# Immingham Green Energy Terminal

10.7 Proposed Further Changes Notification Report

Document Reference: TR030008/EXAM/10.7

FIGURE NUMBER
Figure 2

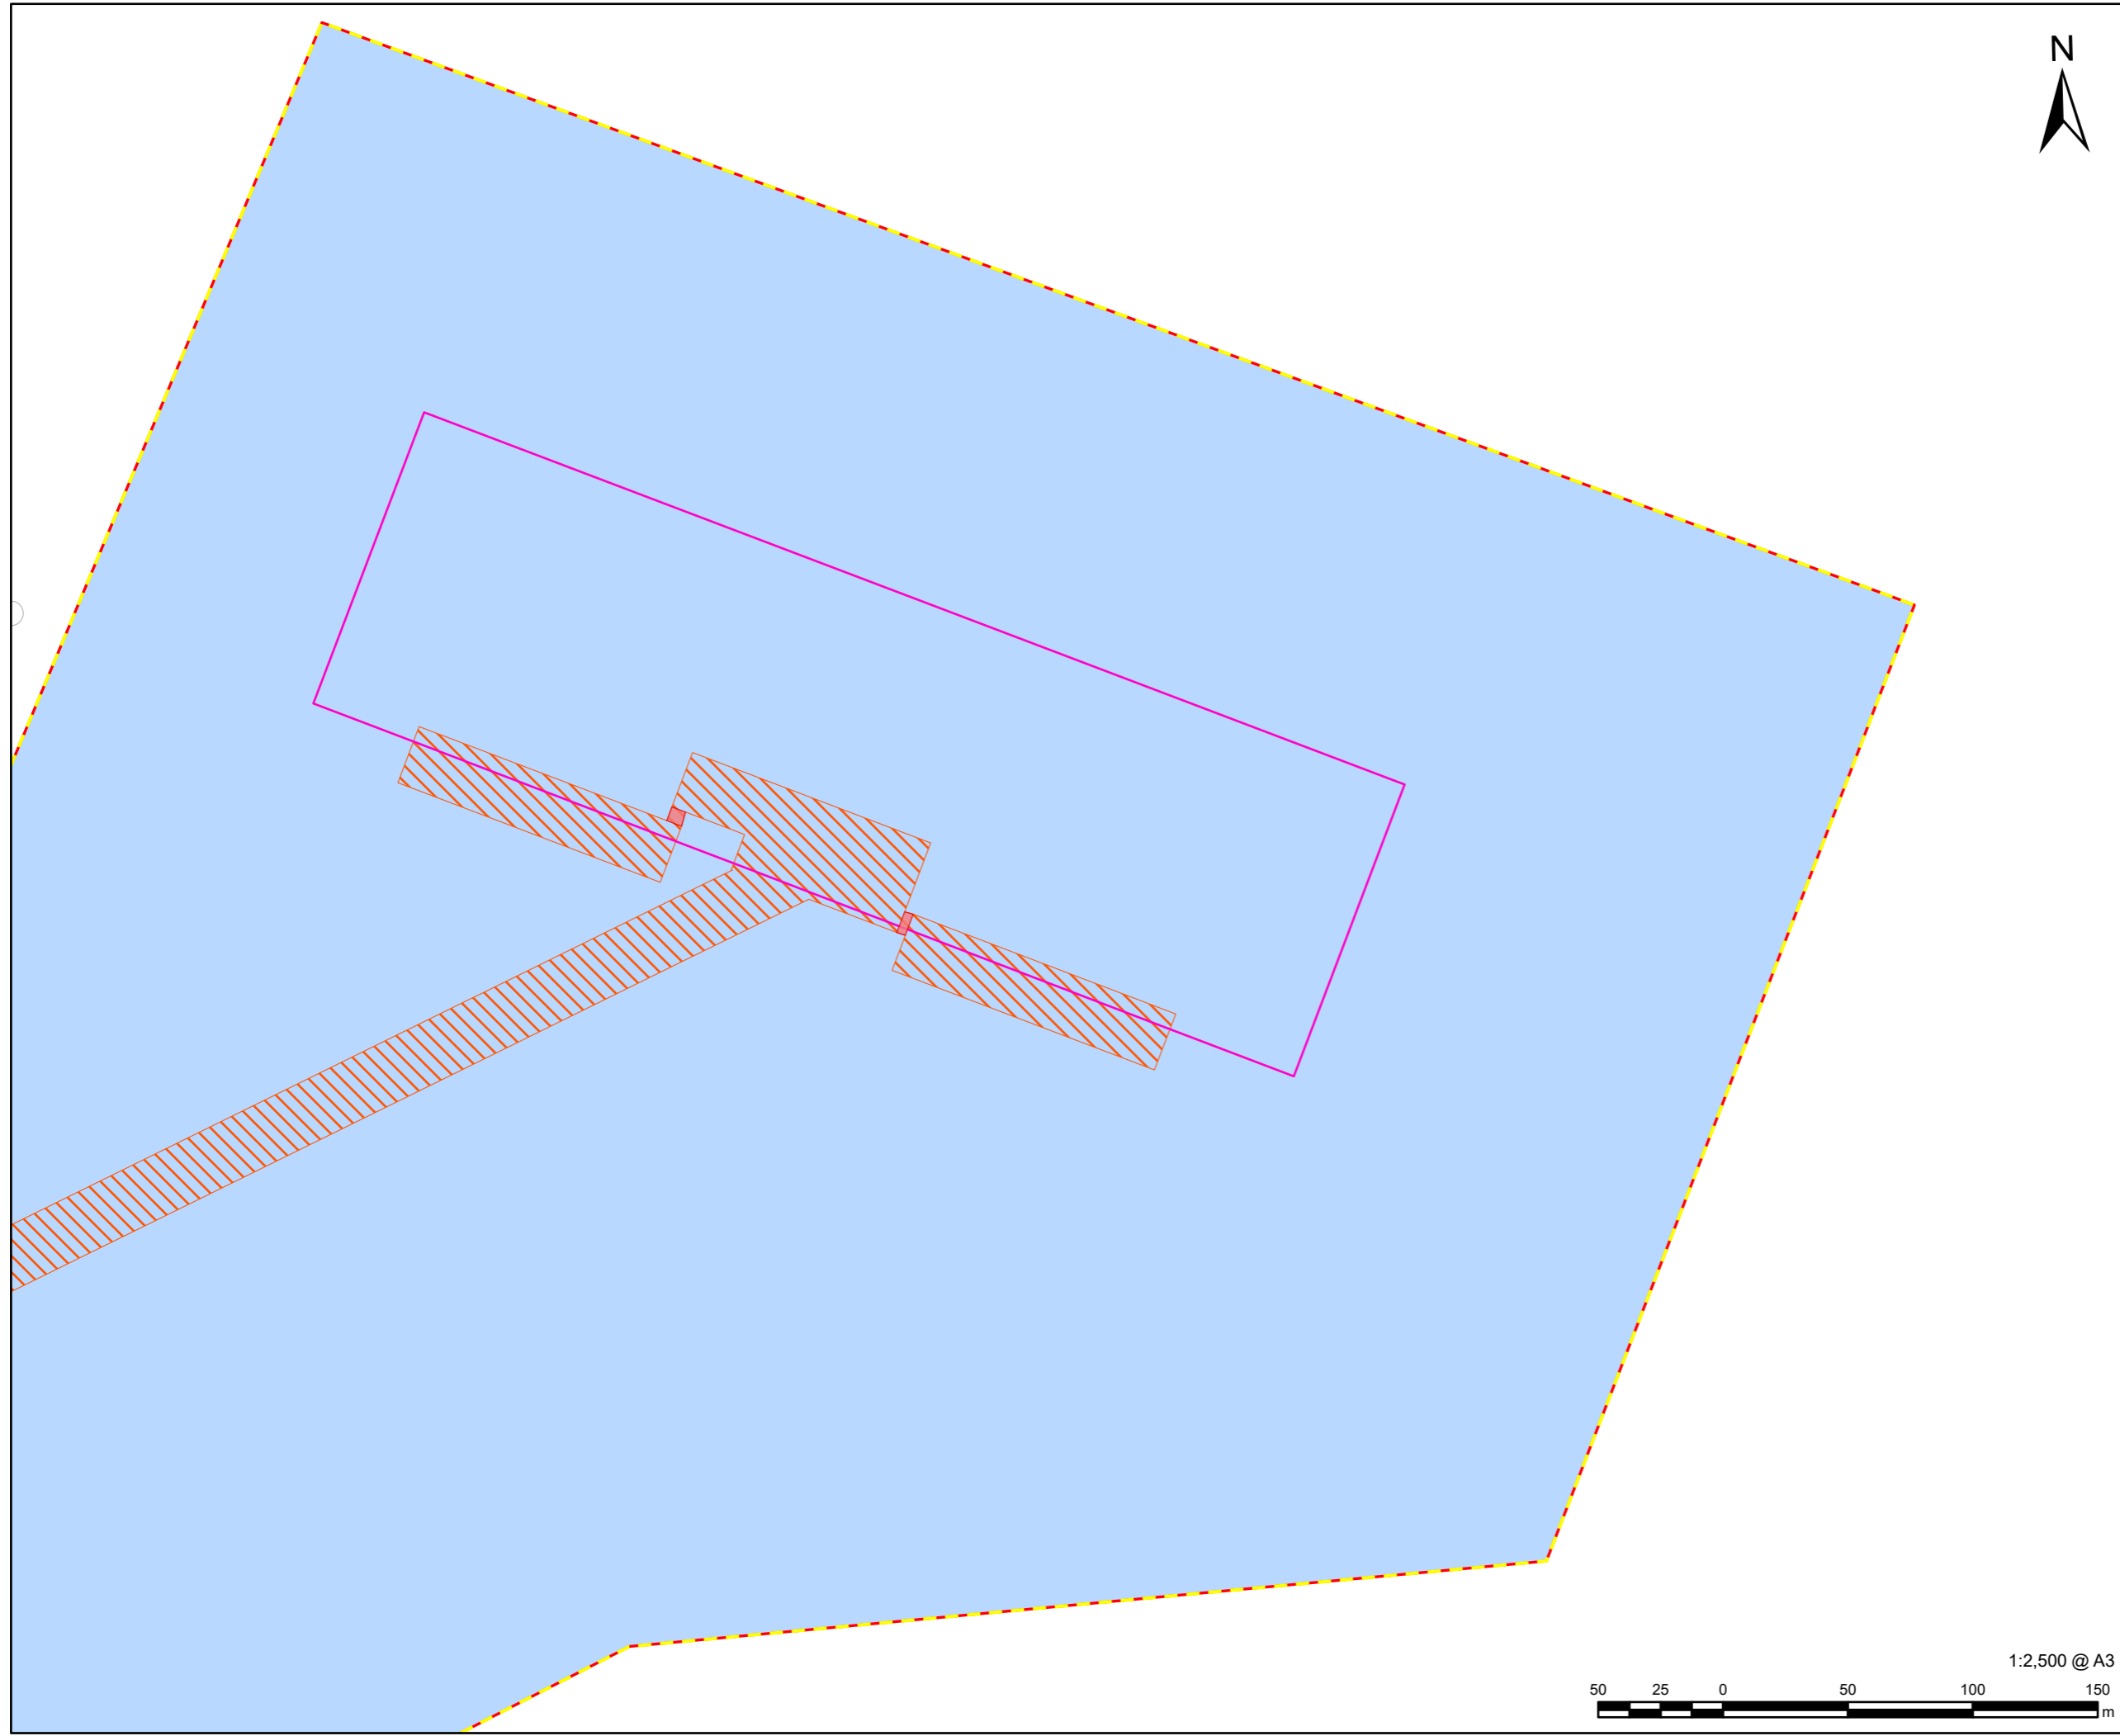
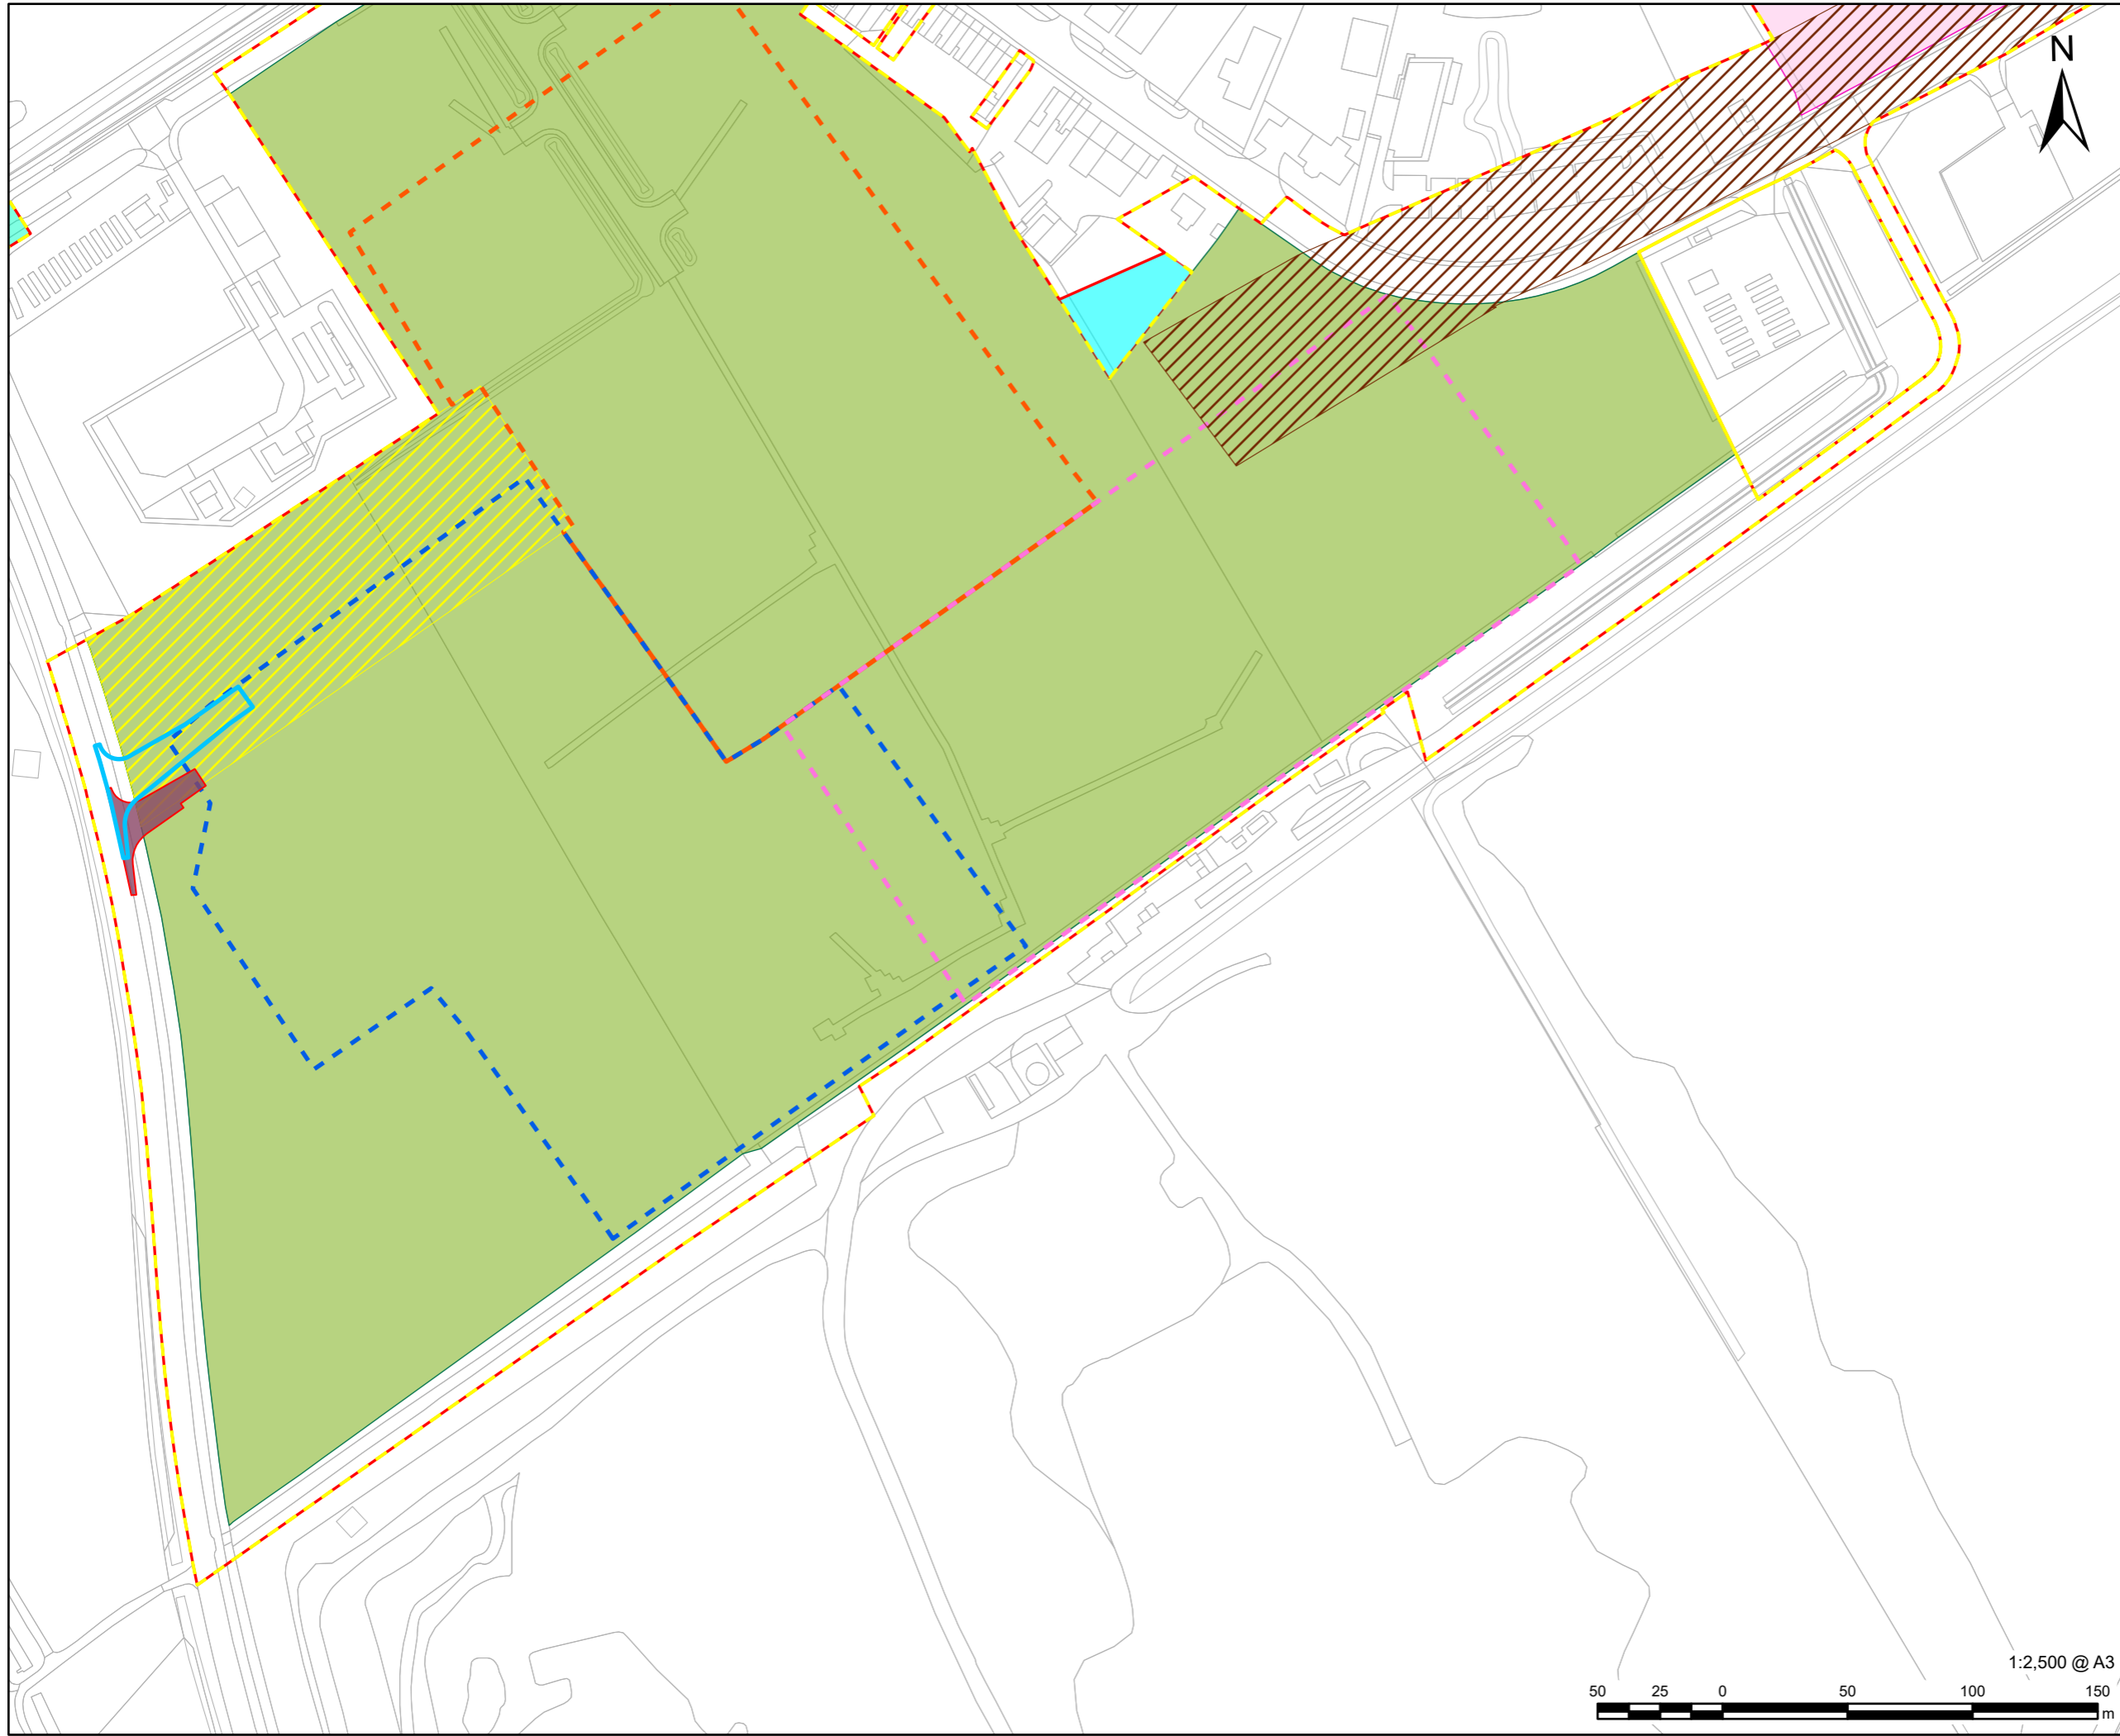
2.7.3 **Appendix 1** illustrates the location of the proposed change and **Appendix 2** illustrates the reduction in the Order limits as a result of the reduction in the area of Work No. 9.
